Subject: FW: DA 8240 and DA 8241 - Works to the Lighthouse Building and works to the Wild Mouse building, Luna Park

Dear Ms O'Rorke, thank you for notifying Precinct about the Luna Park DA's. Although Precinct does not meet until the 30th March, a sub group has reviewed the documents on line and found nothing major to say about the plans. I found the plans somewhat high-level, so would just like to comment on the Wild Mouse as follows :

EXISTING + PROPOSED ELEVATION WEST

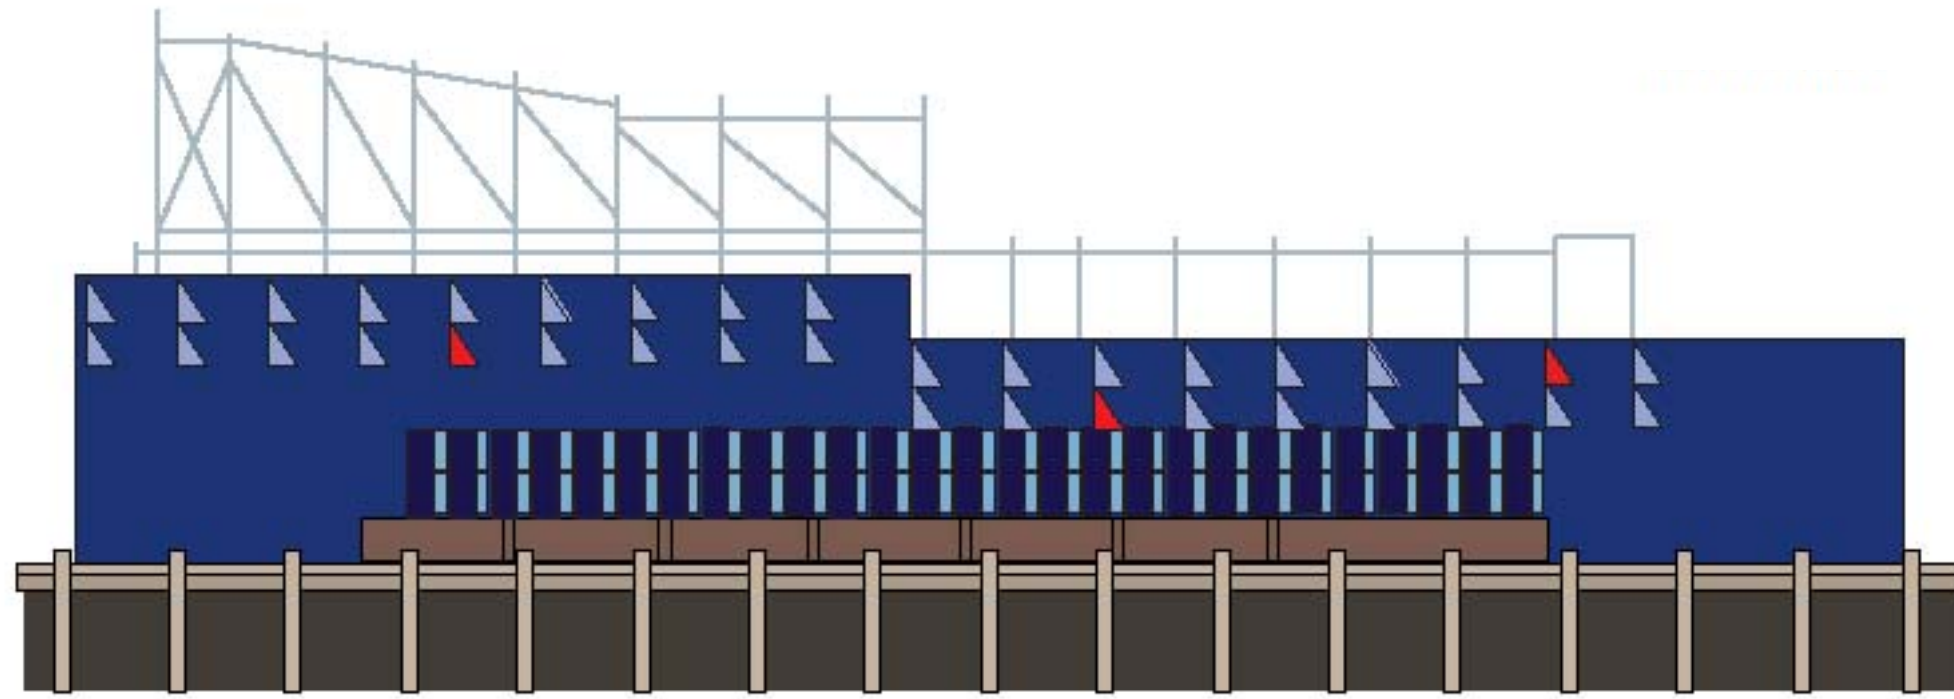
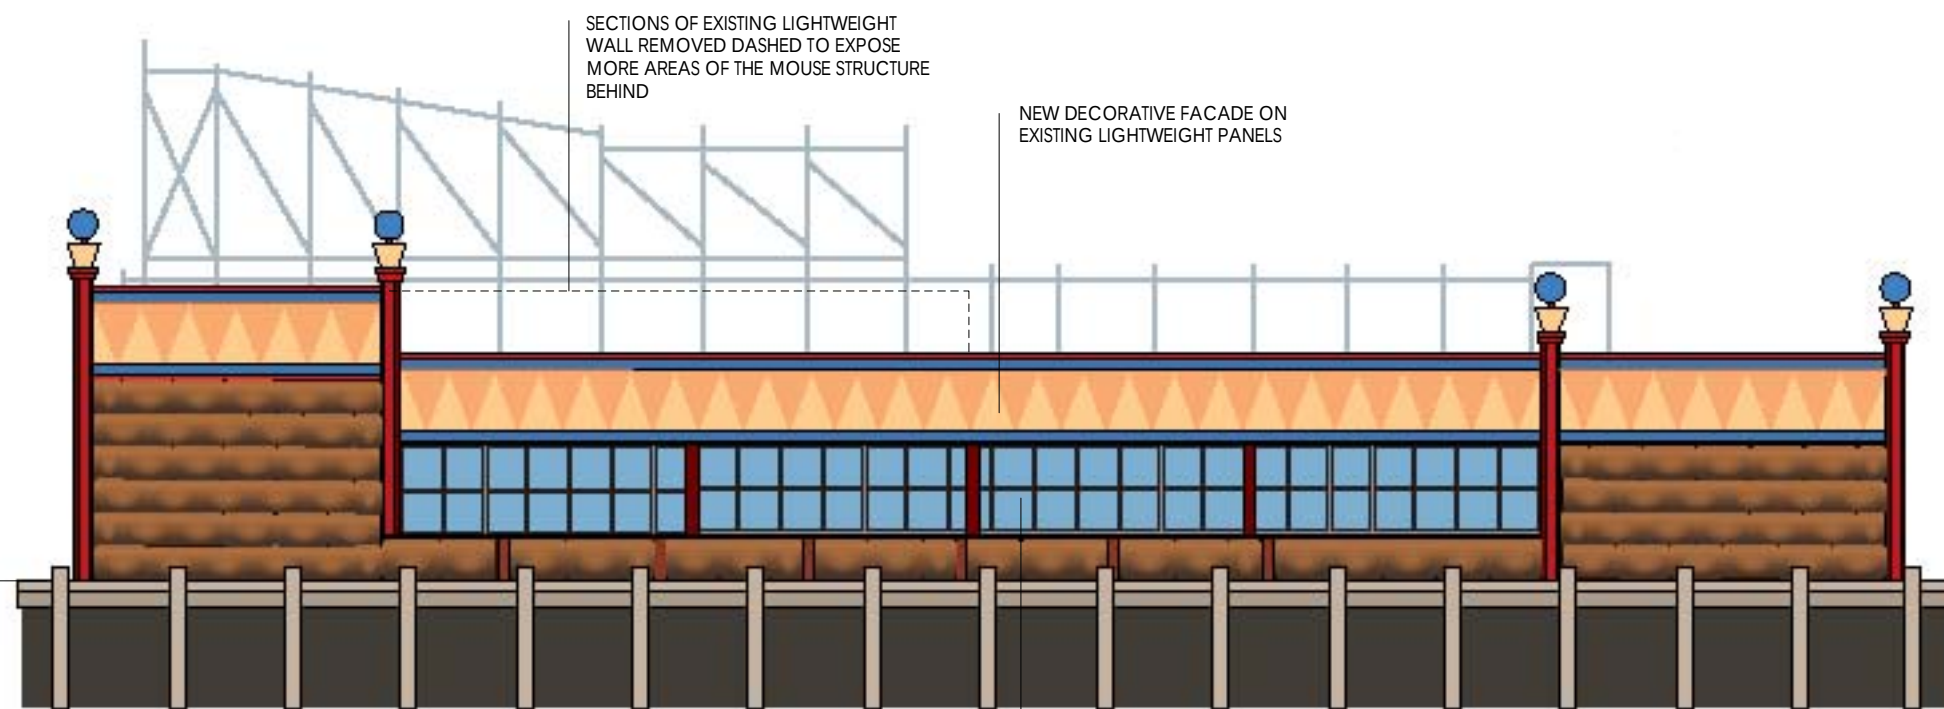
- a) the western facade should not encroach on the boardwalk more than the present western facade
- b) would removing some of the wall release more mechanical noise from the mouse? Not a good thing if so
- c) I thought the original concept for the wild mouse was to have it sitting on top of a stylised yellow cheese. It was painted blue ages ago. Now the faux rusticated castellation is a further departure.
